From: Richard Martin
Sent: 29 September 2017 11:14
To: 'T Stevens'
Cc: Juan Baeza
Subject: Marshall Clark - TPO Application x4 Sites

From: T Stevens [REDACTED]
Sent: 26 September 2017 15:31
To: Richard Martin
Cc: Ed; Zac Denton; Juan Baeza
Subject: Area 4 Parklands - Cowdray Drive

PARKLANDS / COWDRAY DRIVE

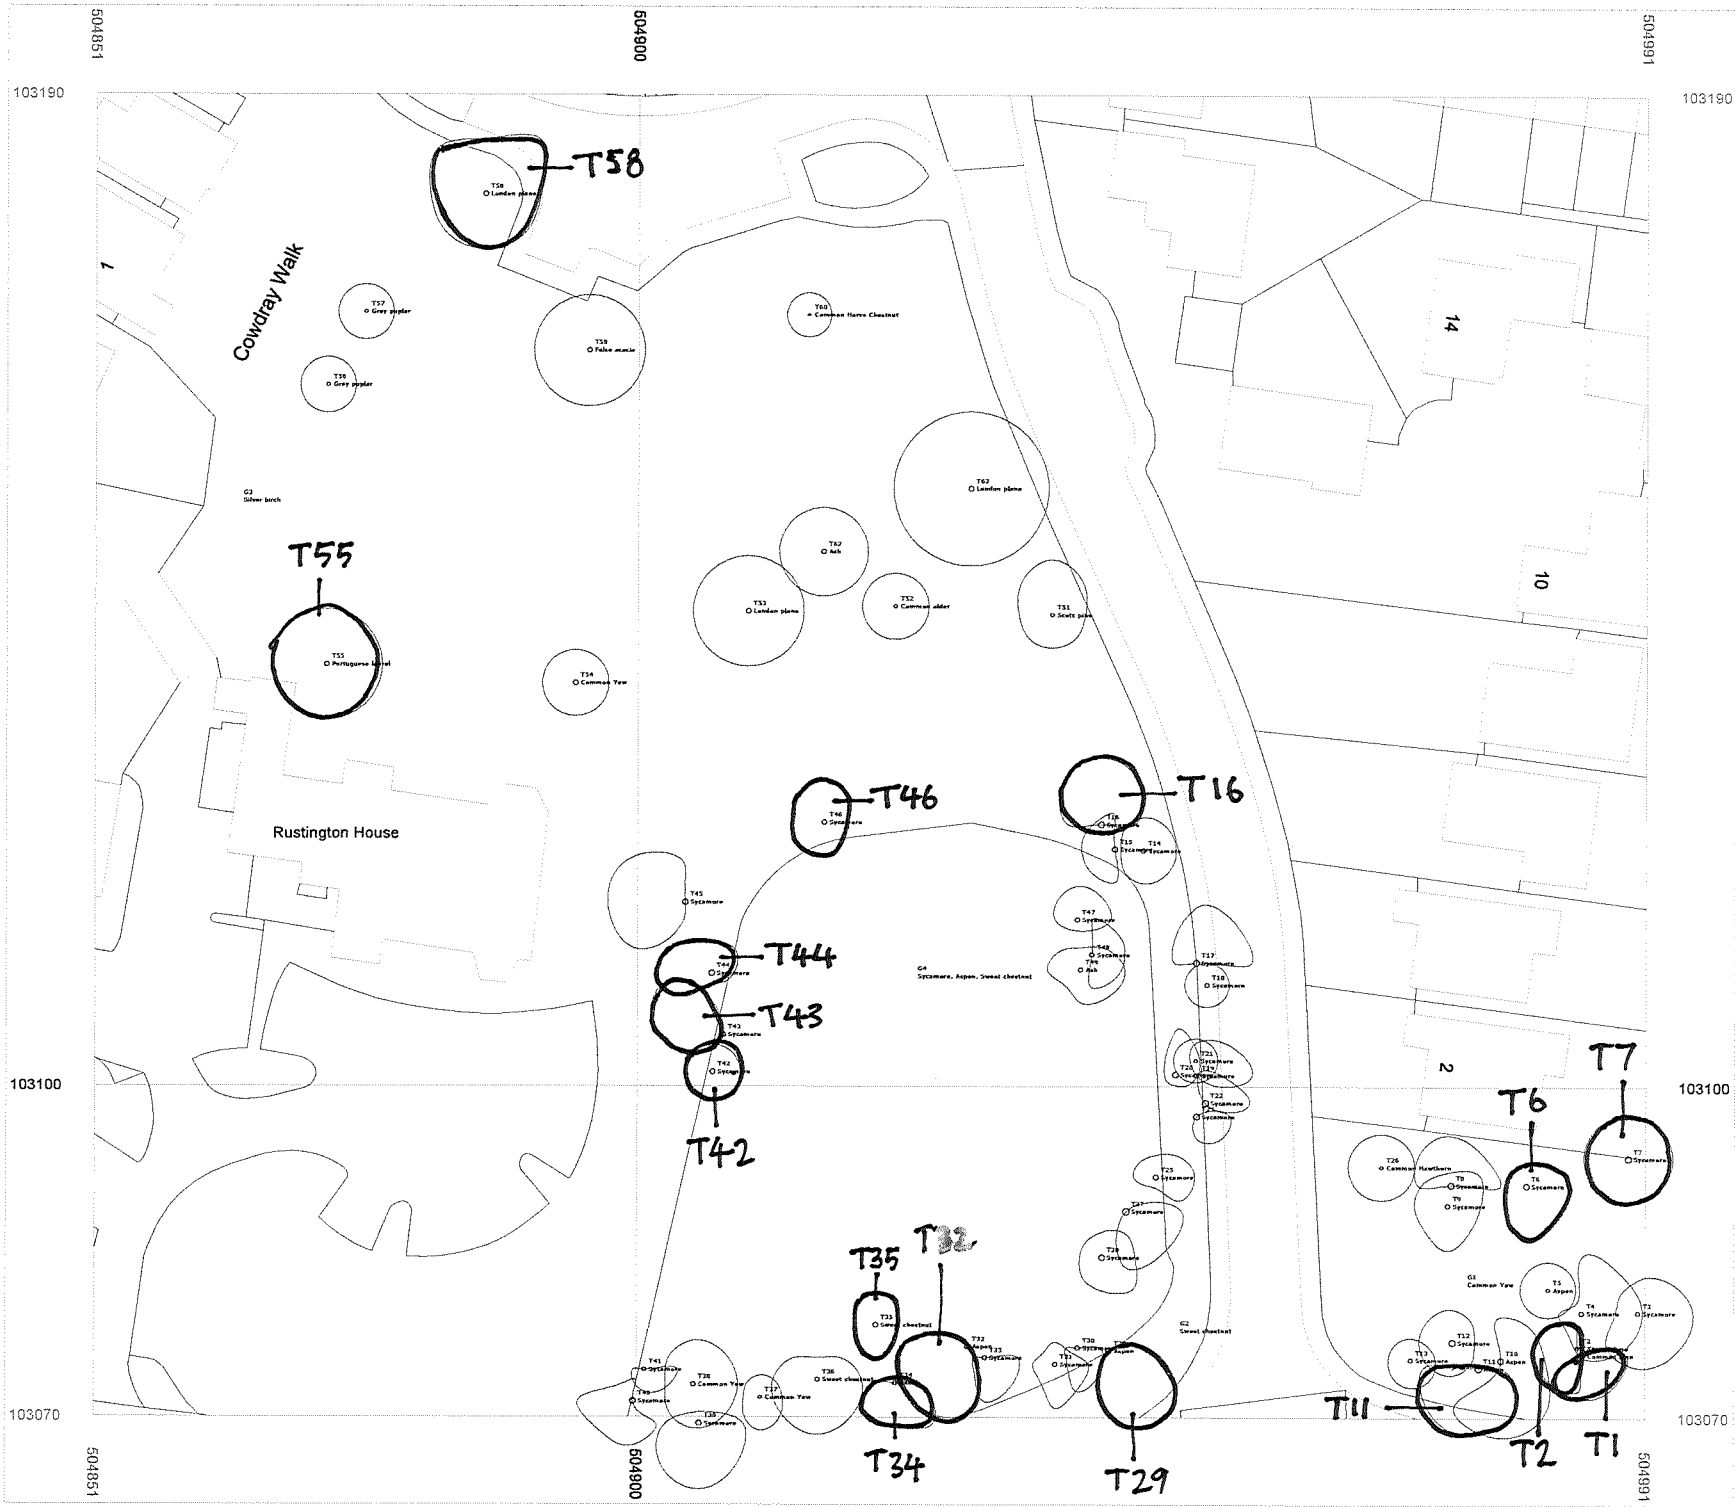
Thank you very much for your attachments. I fully understand why you feel all the information has been submitted, the tree numbers and site plans correspond. It does need to be in a clear and legible format, as things stand this application ought to have been resubmitted as the format is simple a copy of a tree survey/risk assessment and the font size on the plans to identify the trees is too small.

However, due to the time that has elapsed and in an attempt to help you present the information I have spent a considerable amount of time picking out the work requirements that would be subject to an application and identified these on your plans. Please can you double check the information attached, confirming you are satisfied with it to myself and Juan Baeza who will then put this on the planning portal for the public to view.
